CITY OF ALBUQUERQUE

RE: **Lot 31 Block 5 Unit 5 SAD 227**
Unser Cliffs
8036 Victoria NW
Grading and Drainage Plan
Engineers Stamp Date 10/18/19 (E10D067)

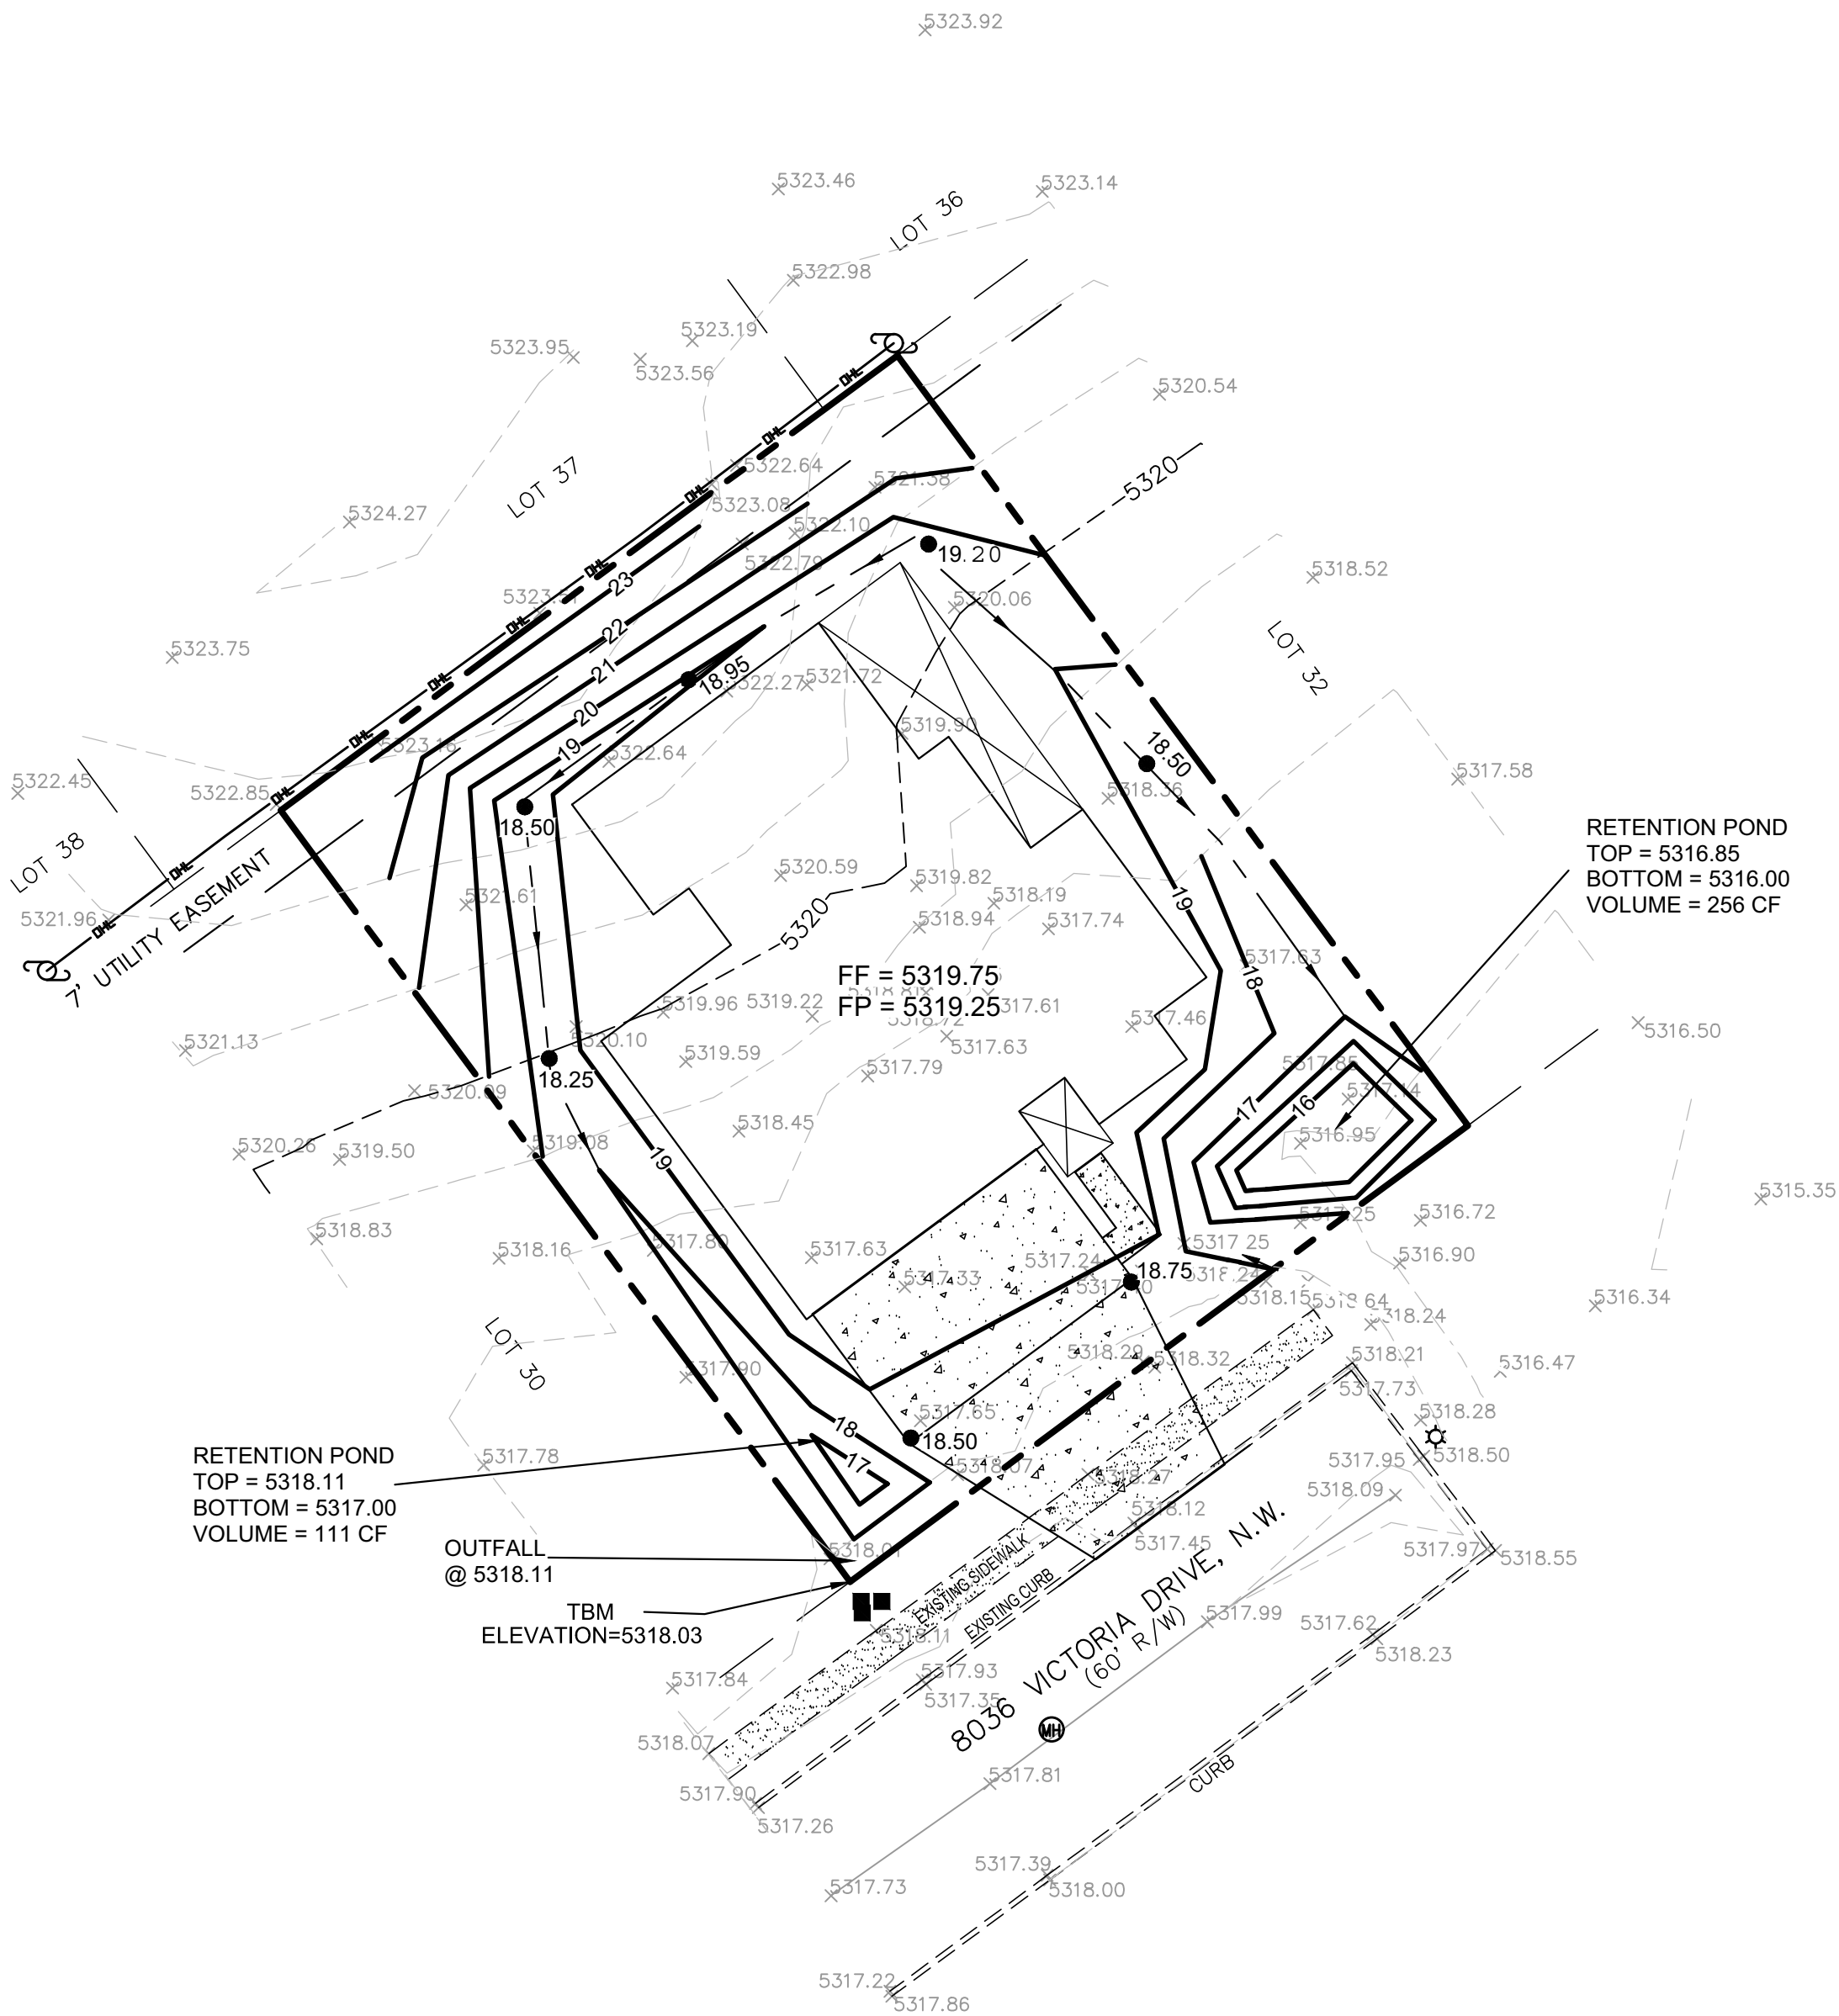
- Clean and sweep street and sidewalk.
- Still working on PAD.
